Subject: BL-25-00007 Curley Miller - Notice of Application

Please review the following Boundary Line Adjustment Application: BL-25-00007 Curley Miller. Any comments need to be received by **5 PM on May 13, 2025**.

TO: All Staff
FROM: Public Works Plan Review Team
DATE: May 12, 2025
SUBJECT: BL-25-00007 Curley Miller

PREPARED FOR DON MILLER SECTION 4 AND SECTION 33 TWN. 19 N., RGE. 15 E. AND TWN. 20 N., RGE. 15 E., W.M. KITTITAS COUNTY WASHINGTON		
DWN BY <b>E.Z./G.W.</b>	DATE <b>06/2025</b>	JOB NO. <b>230052</b>
CHKD BY <b>D.L.P.</b>	SCALE <b>1" = 200'</b>	SHEET <b>1 OF 2</b>

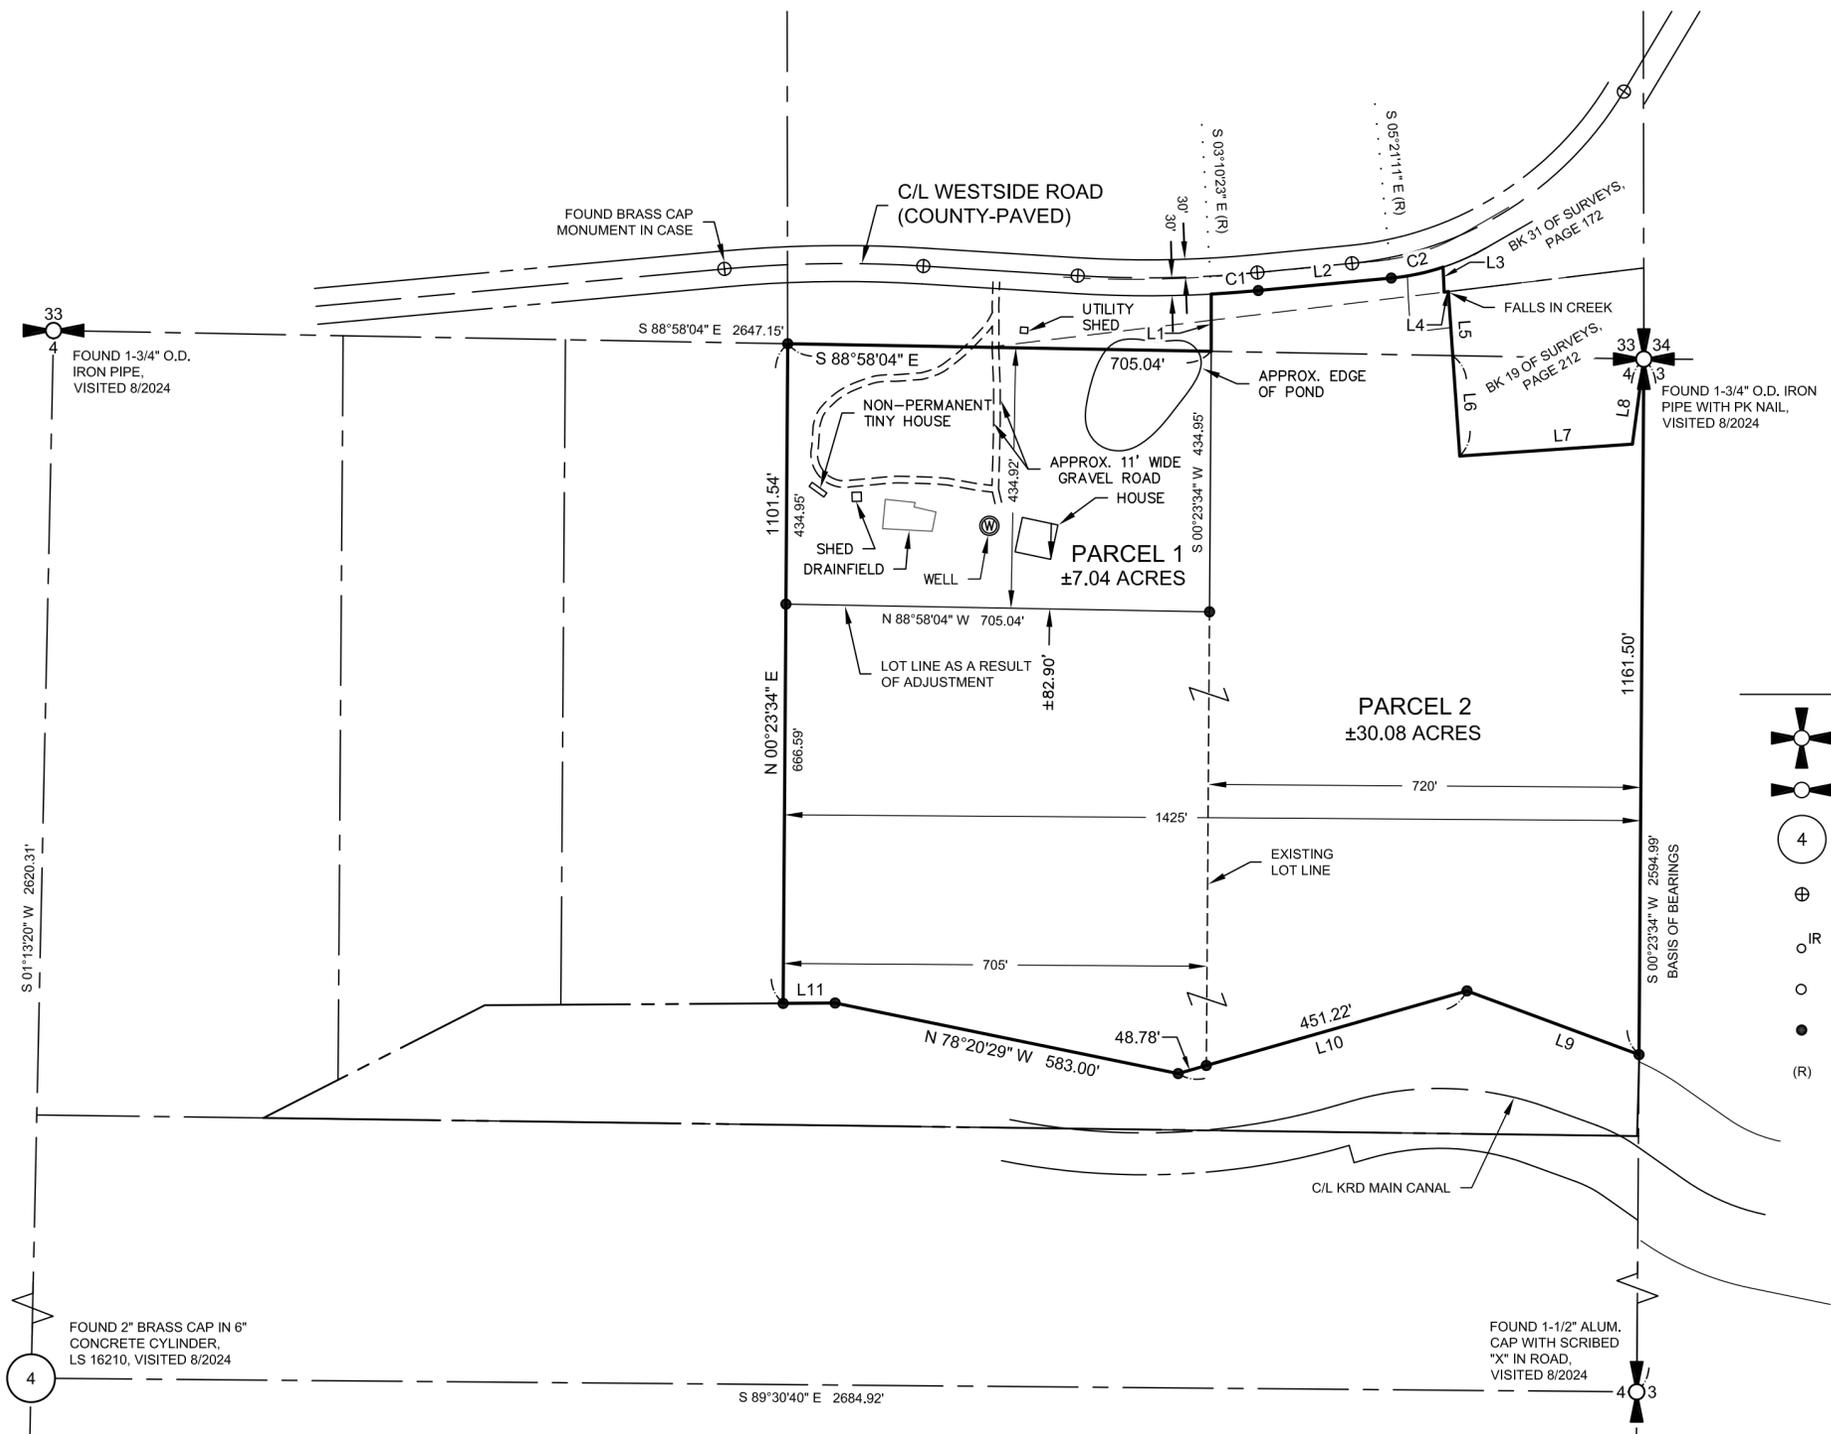
SURVEY	<ol style="list-style-type: none"> 1. Please note or show Basis of Bearing. 2. County Road should include surfacing, and ownership (paved county r/w). 3. Please show the body of water located near the NE corner of Parcel A. While KCC:16.24.060 calls out a meander line, it would be acceptable to depict the location of the edge of water. This does not need to be survey accuracy. 4. There is an erroneous setback distance shown located south of the house on Parcel A. (JT)
TRANSPORTATION CONCURRENCY	No transportation concurrency application is required for this project. (KAH)
FLOOD	Parcels 015534 and 022534 are not within a FEMA identified special flood hazard area (100-year floodplain). A floodplain development permit is not required for the project. (SC)
